MODIFICATION TO KINGS FOREST - APPROVAL NO. 08_0194(MOD4)

The proponent seeks to modify conditions A13, 3, 45, 46, 147 and Statement of commitment 18 of the Project Approval

On behalf of local Tweed environmental group I would like to submit the following comments on this proposed modification and I would strongly recommend the Tweed Shire Council department report and recommendations on this proposal.

**FIGURE 17**

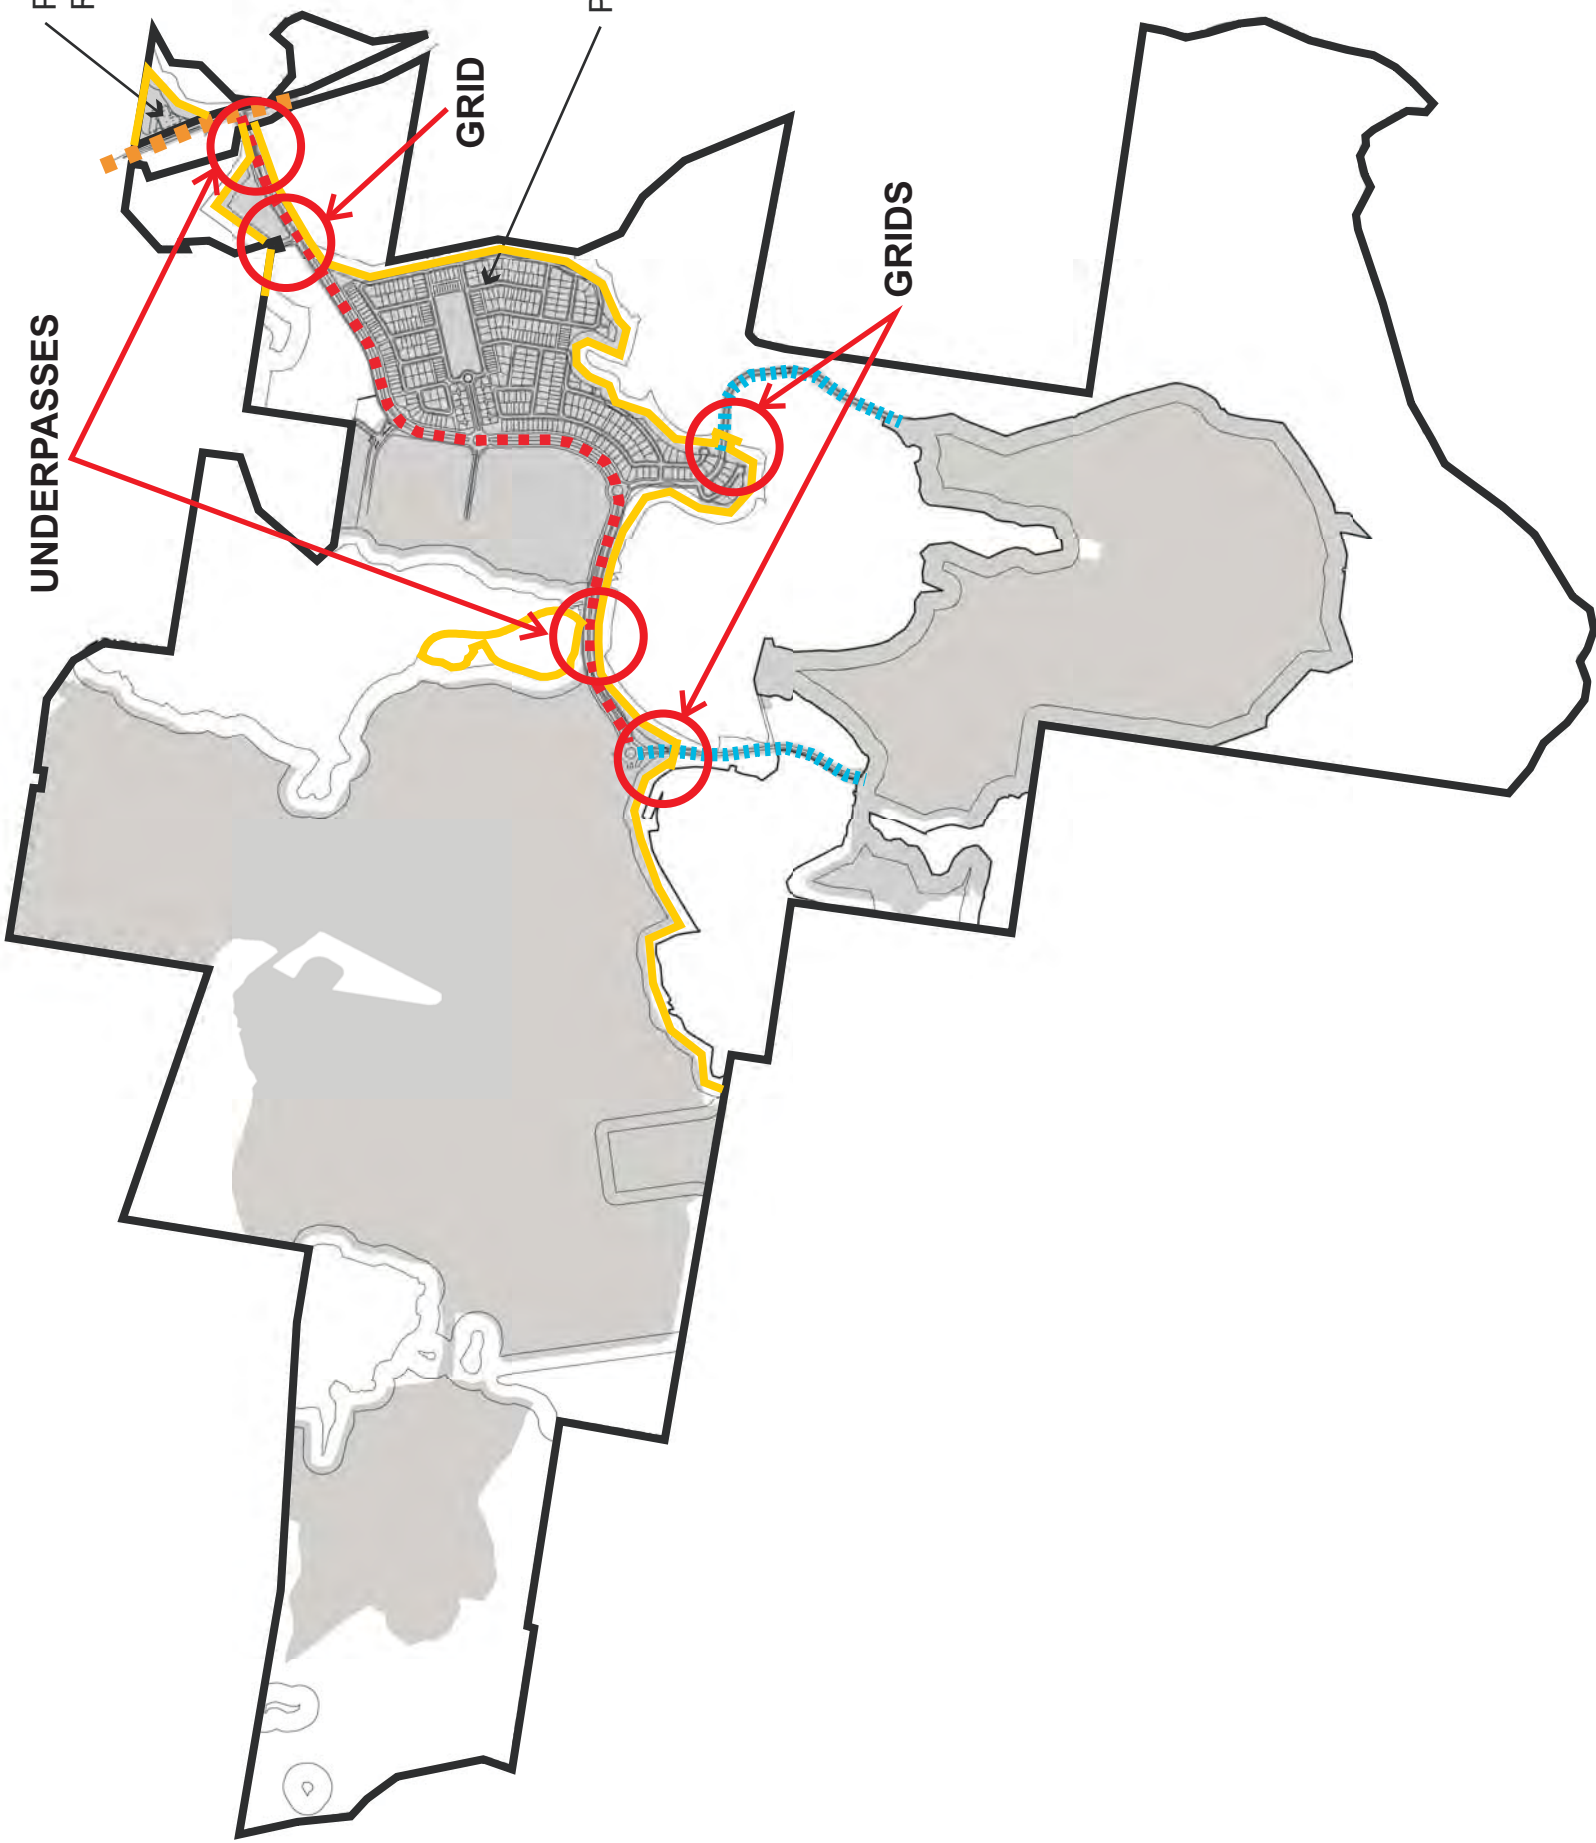
The proposed KPOM includes underpasses near the entrance of the site but does not include any such structures under the roads that traverse environmental areas. It also depicts only temporary fencing on either side of these roads. The KPOM also relies heavily on "cattle grids" as a way to keep koalas off the development site. This technology is unproven and would not be effective in deterring dogs from accessing koala habitat and, more importantly, koalas and other wildlife will be vulnerable to vehicle strike when they are forced to cross unfenced roads to reach neighbouring environmental areas.

However maps showing these areas fail to depict any fencing through major environmental zones

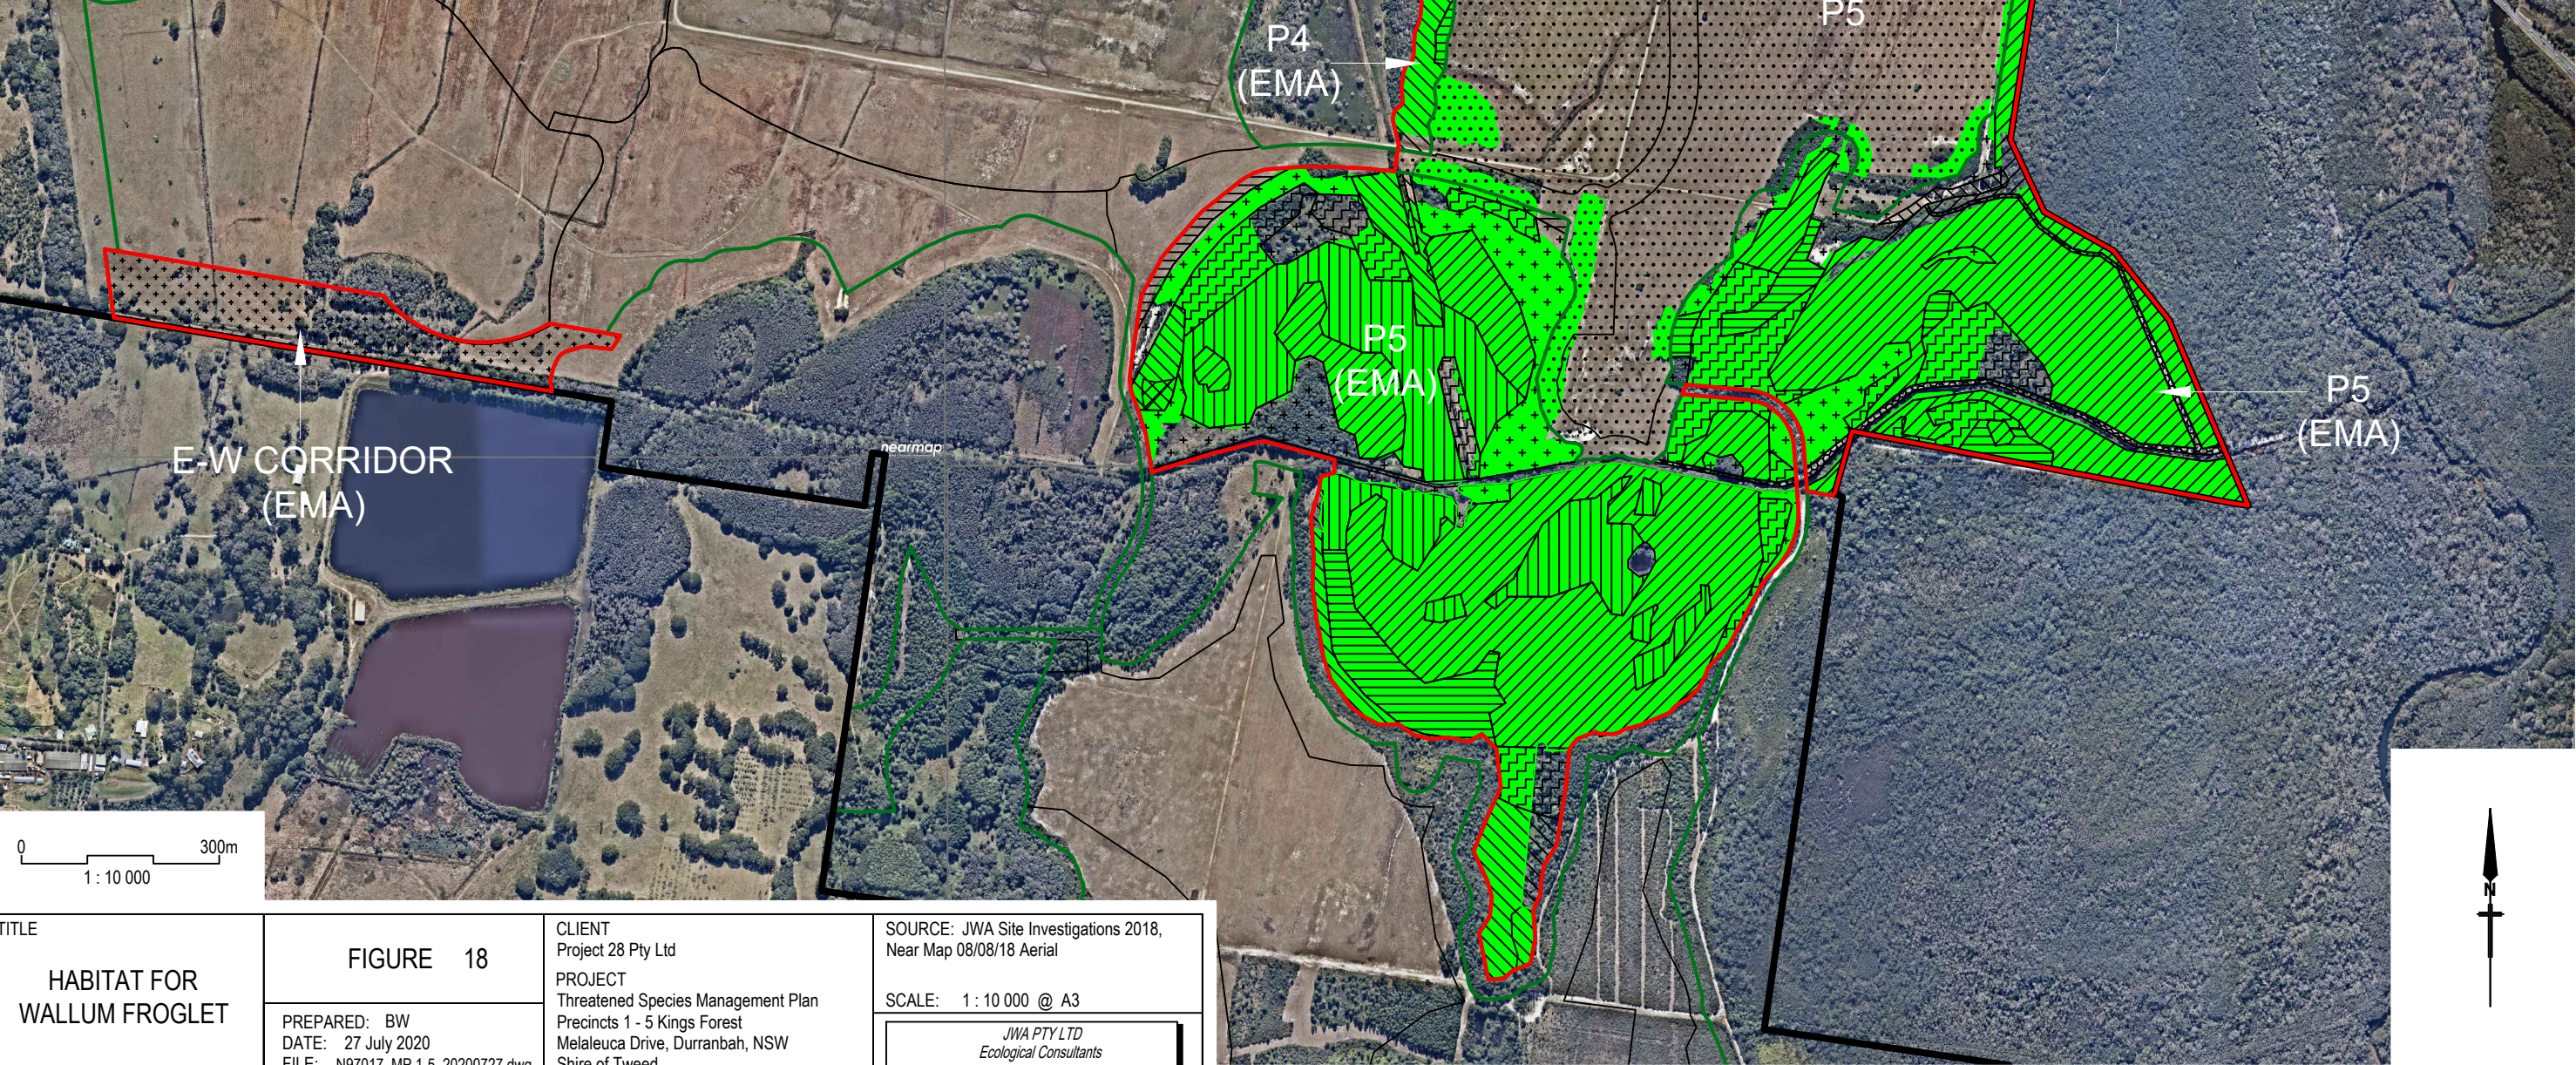
- The corridor depicted in Figures 18 & 22 is only 50m wide at best and has a break in it. It is not shown as a continuous linkage extending across the Kings Forest site towards the Eviron Rd koala corridor as it was required to.
